WEST SUSSEX COUNTY COUNCIL CONSULTATION

TO:	Arun District Council FAO:Ms M Tomalova
FROM:	WSCC - Highways Authority
DATE:	14 June 2021
LOCATION:	47 South Way Bognor Regis PO21 5EY
SUBJECT:	BE/80/21/DOC Approval of details reserved by condition imposed under BE/43/20/PL relating to Condition Nos 3 - materials & finishes, 4 - screen walls & fences, 5 - dustbin storage, 7 - covered & secure cycle parking, 9 - site set up during construction, 10 - surface water drainage, 11 - contamination and 12 - electric vehicle charging.
DATE OF SITE VISIT:	n/a
RECOMMENDATION:	More Information
S106 CONTRIBUTION TOTAL:	n/a

Facilities Site Plan

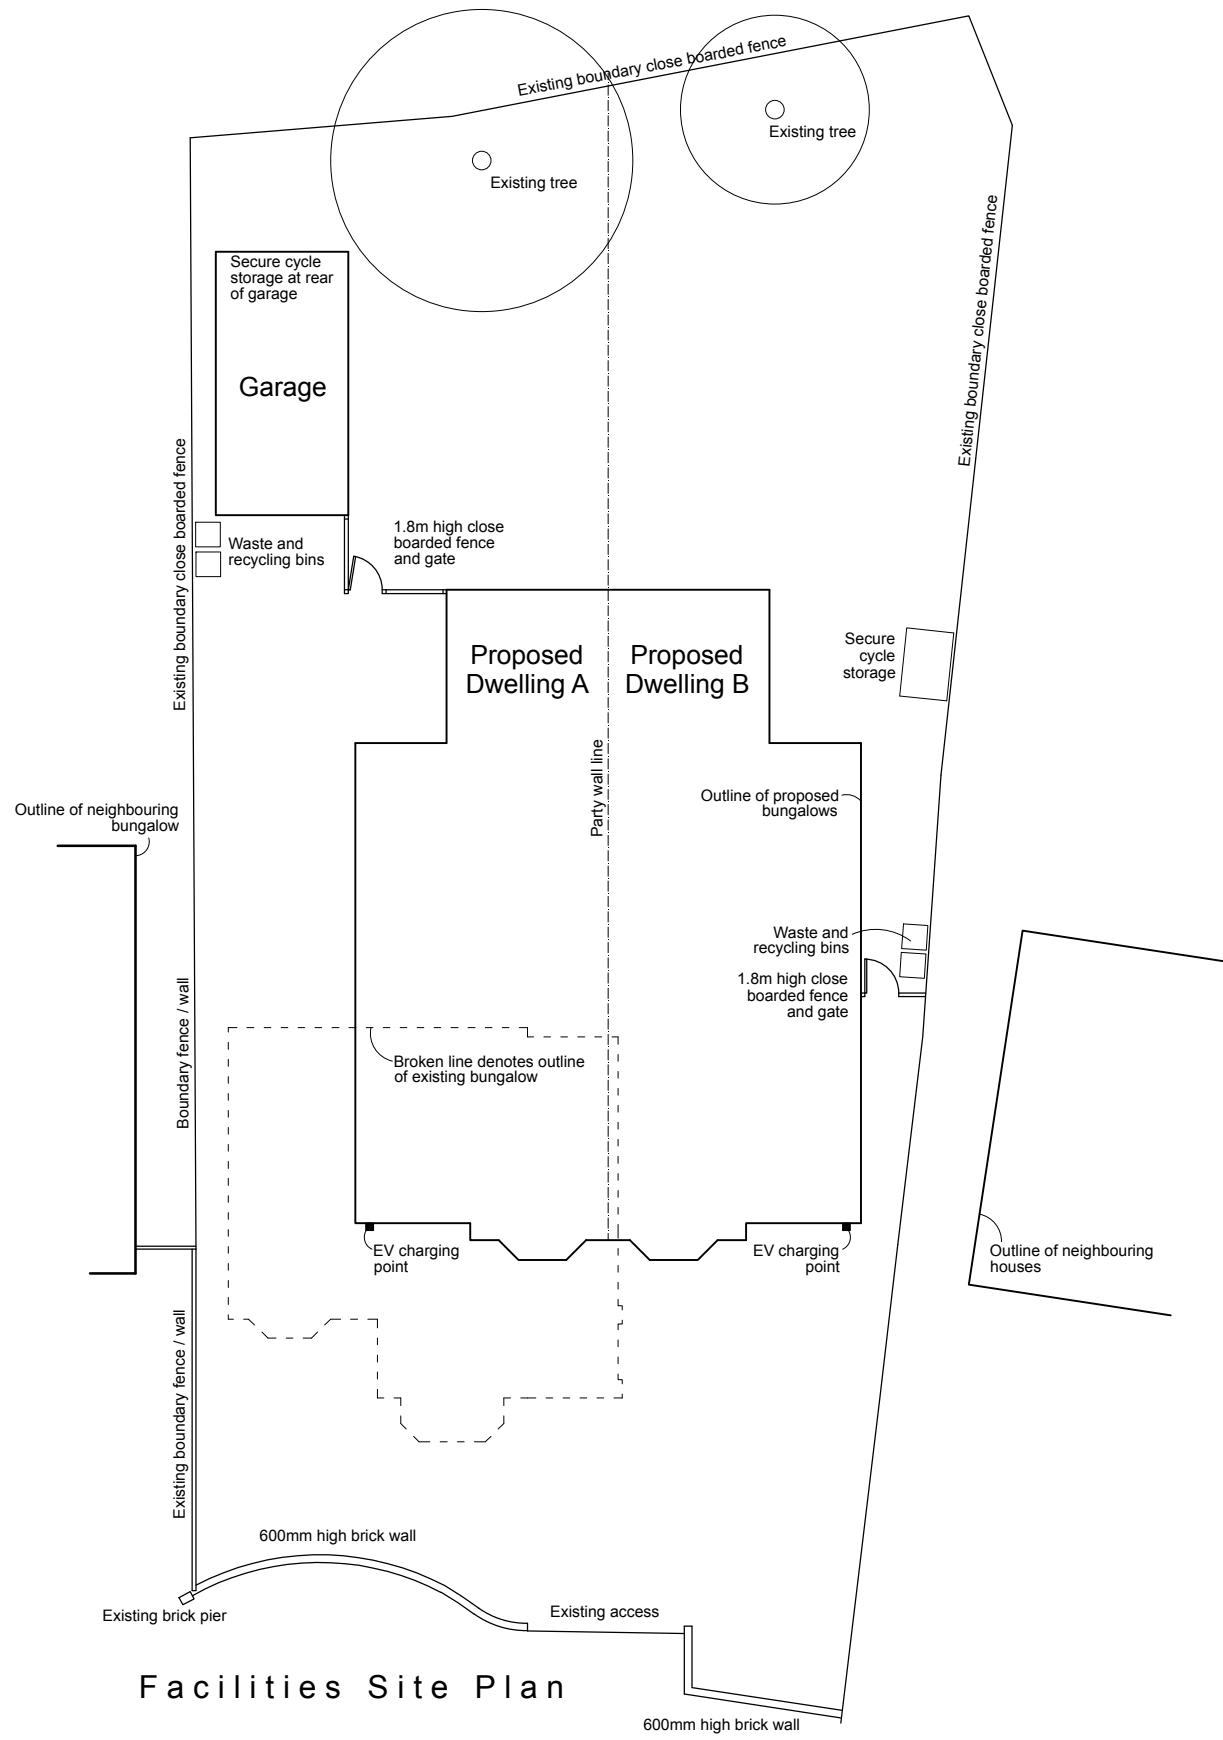
The Facilities Site plan demonstrates EV Charging Point at the southern point of each dwelling. This would be acceptable for Building B. Building A should also have EV Charging point installed within the proposed garage. This detail should be demonstrated on a revised plan.

Please raise the above matter regarding EV Charging for Building A and re-consult.
